Single storey side and rear extension. Conversion of loft space into ensuite and new front boundary wall with gates.

14 Merry End Middleton-On-Sea

*Representations of Middleton on Sea Association (MOSA) in respect of Planning Application M/66/19/HH - for works to 14 Merry End, Middleton on Sea.*

DRAWING
**LOCATION PLAN
SITE PLAN**
DRAWING NO
292/01
SCALE
DATE
1:100
JUNE 2019
DRAWN
CHECKED
LA

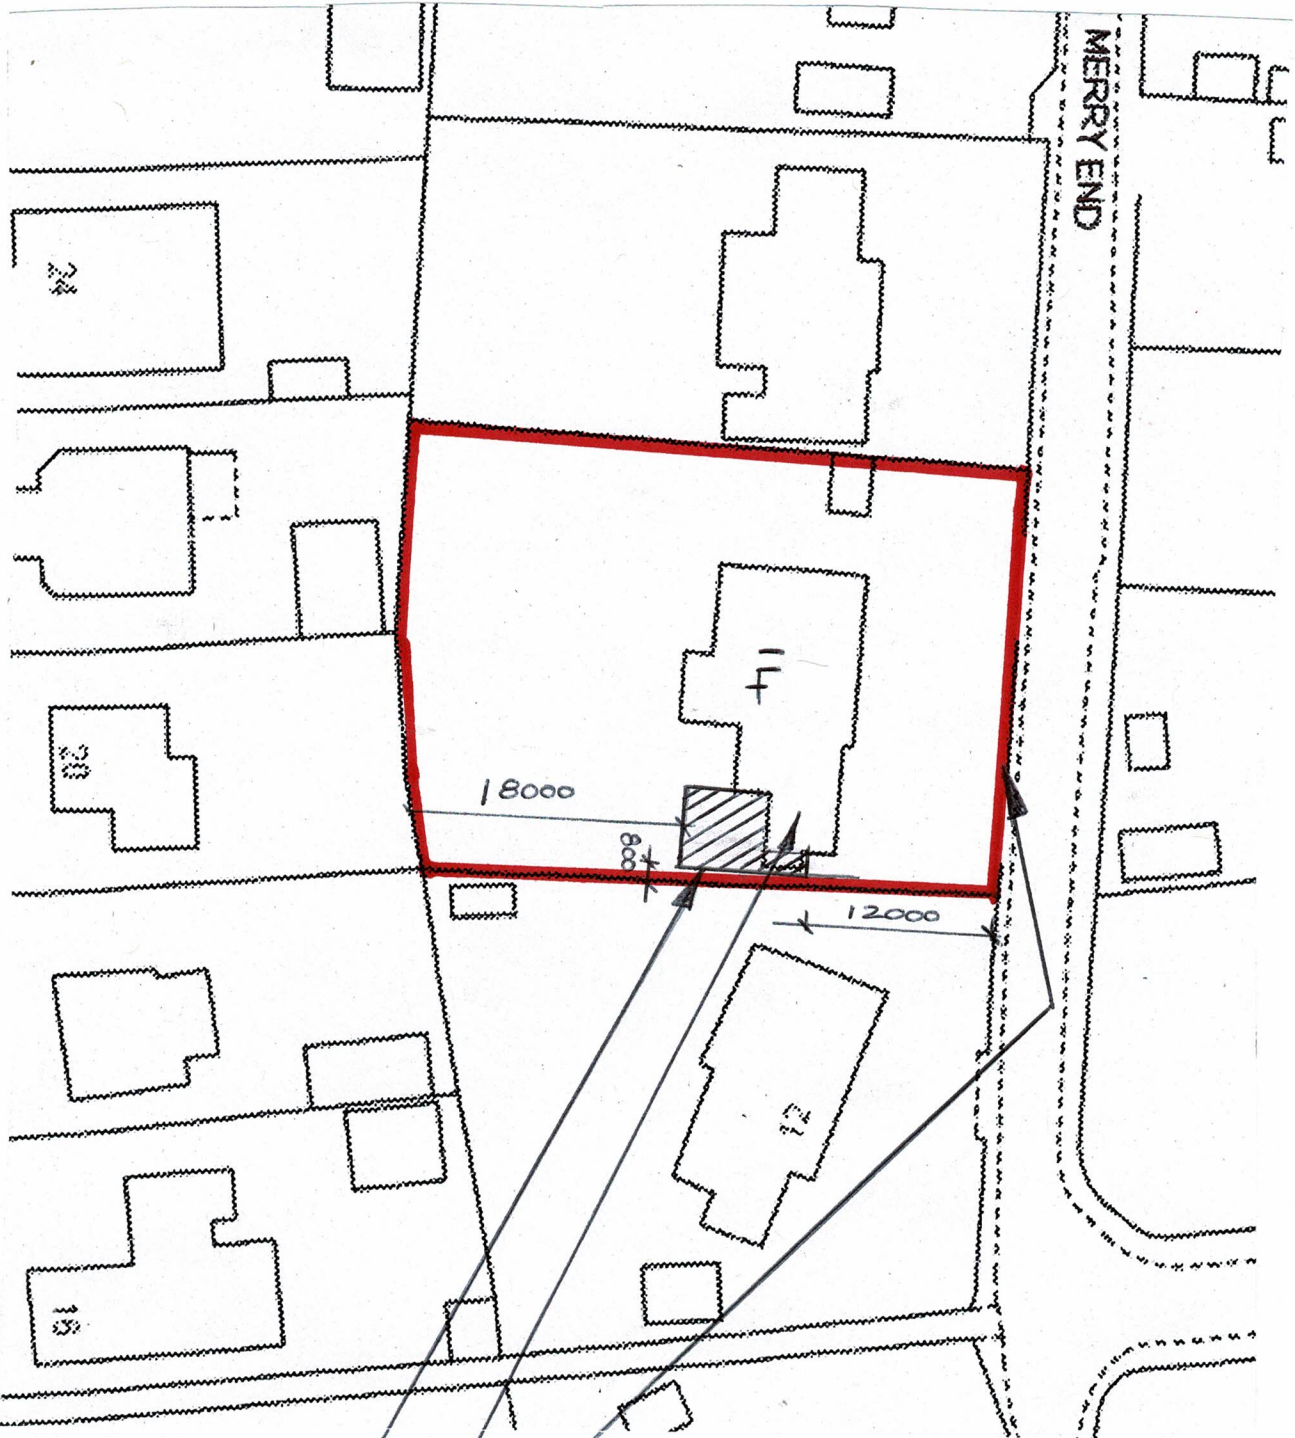
*Whilst not wishing to object to the proposed extension works to the living space of 14, Merry End, MOSA opposes the proposed 1.8m high boundary wall and wooden gates, which are considered to be out of keeping with the adopted Middleton-on-Sea Village Design Statement and the philosophy behind the designation by Arun District Council of the Area of Character. The primary concern is that the proposals will introduce a regrettable visual narrowing and enclosure of what is in effect a narrow country lane and that this will detract from the generally open street scene that defines the south side of Merry End.*

*The proposed wall and gates are being advanced principally as a means of reducing the impact of a large motorhome frequently parked at the front of the premises, which MOSA have sought to discourage under the terms of a covenant that applies across the wider Middleton on Sea estate.*

*MOSA have therefore been in liaison with the applicants in order to try and secure a softening of the visual impact of this proposal by the introduction of wrought iron gates (rather than solid wooden ones) and preferably the use of soft landscaping/trellis panels to provide the means of enclosure.*
